Our ref: STH20/00139/04
Contact: Andrew Lissenden 0418 962 703
Your ref: SSD-14394209

STATE SIGNIFICANT DEVELOPMENT 14394209 – NEW HIGH SCHOOL, ASSOCIATED INFRASTRUCTURE AND COMMUNITY CENTER IN BUNGENDORE – PUBLIC EXHIBITION OF ENVIRONMENTAL IMPACT STATEMENT

13 Fencing Strategy

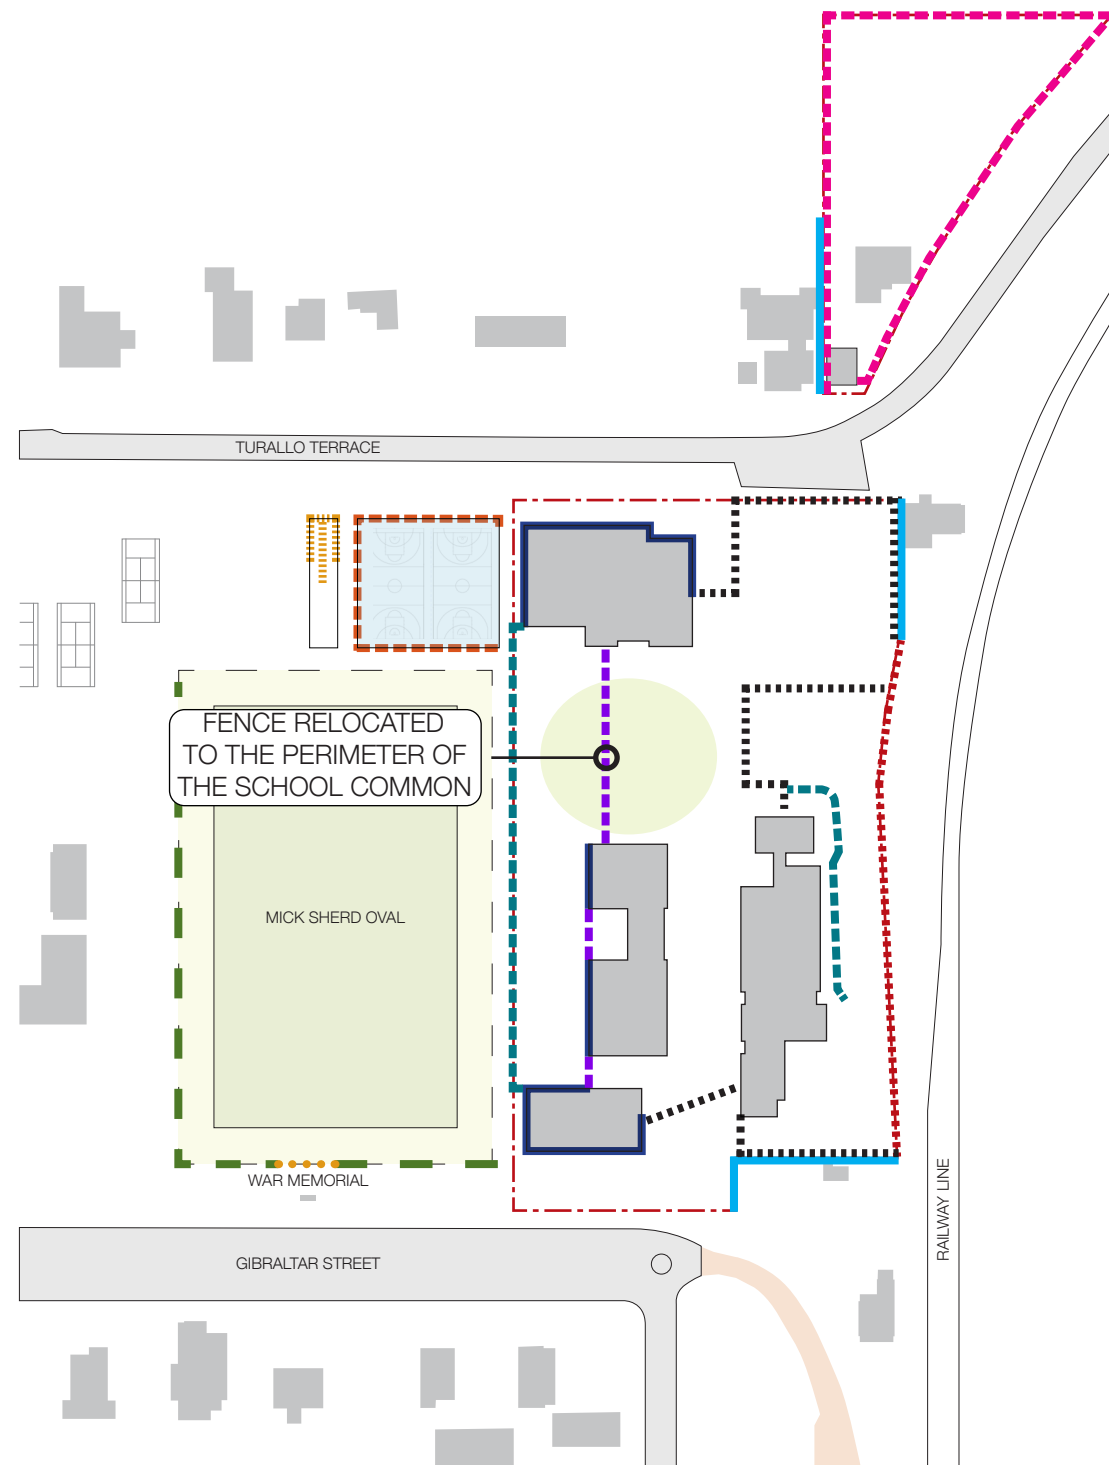
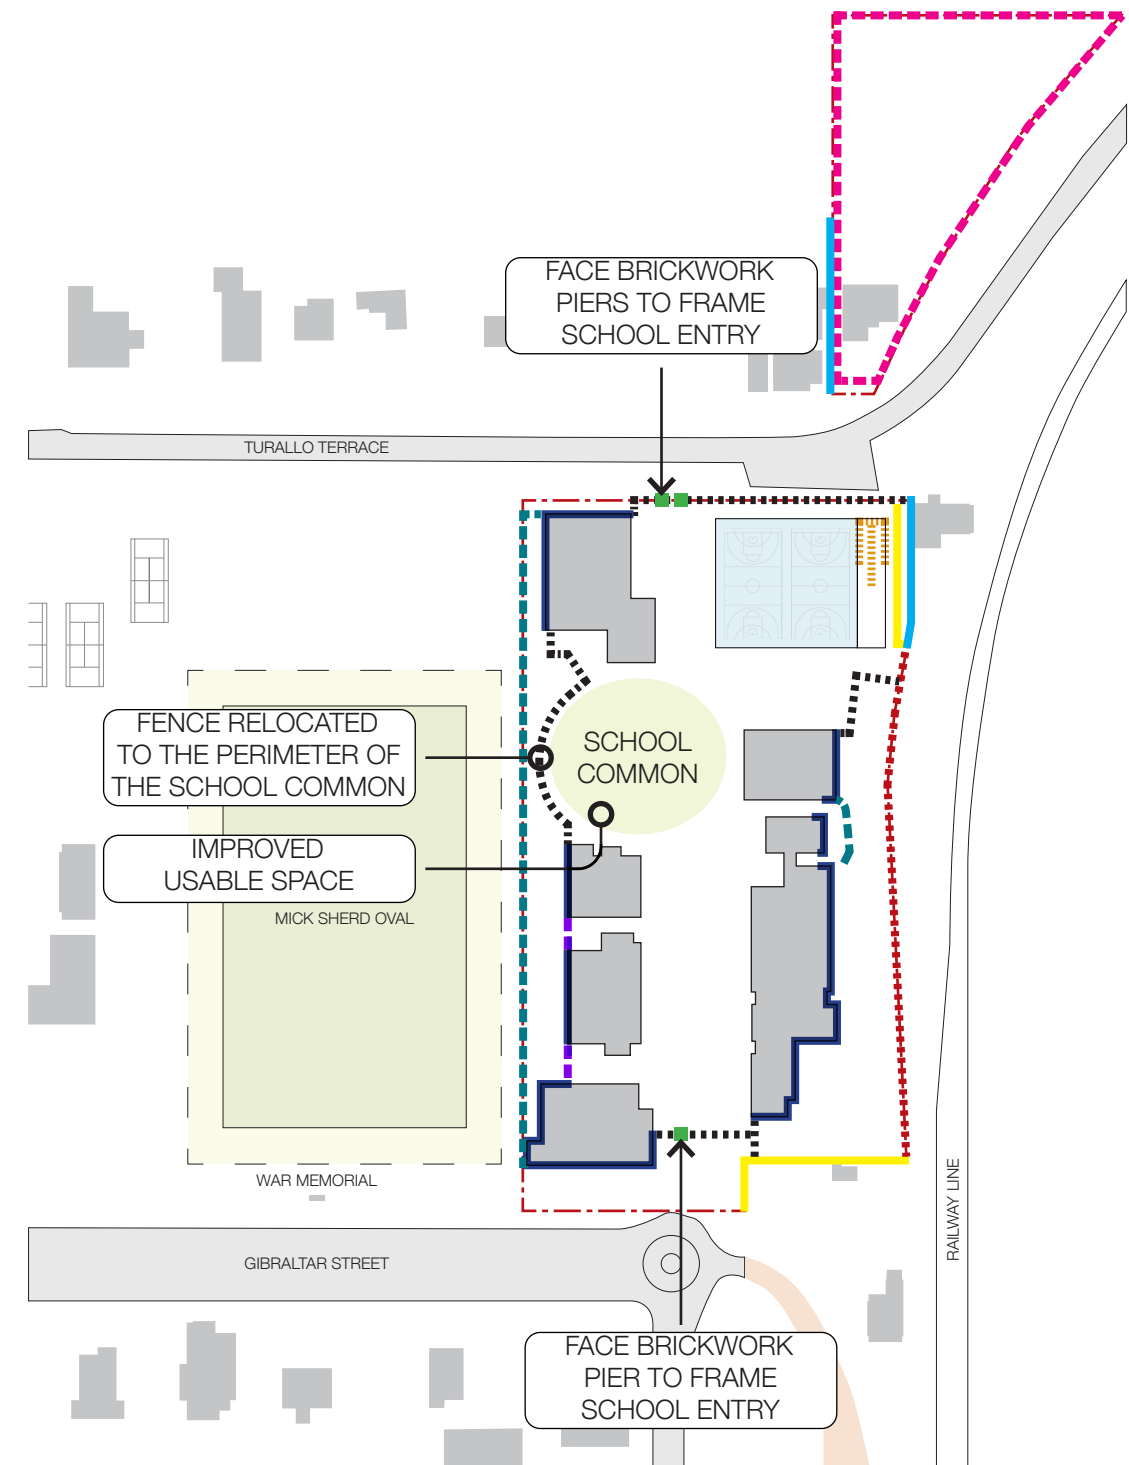
In addition, Figure 3-16 Fencing plan of EIS does not indicate the new fencing between the rail corridor and the project site for the proposed agricultural plot to the north of the main project site. A new fence between the proposed agricultural plot and the rail corridor shall be installed
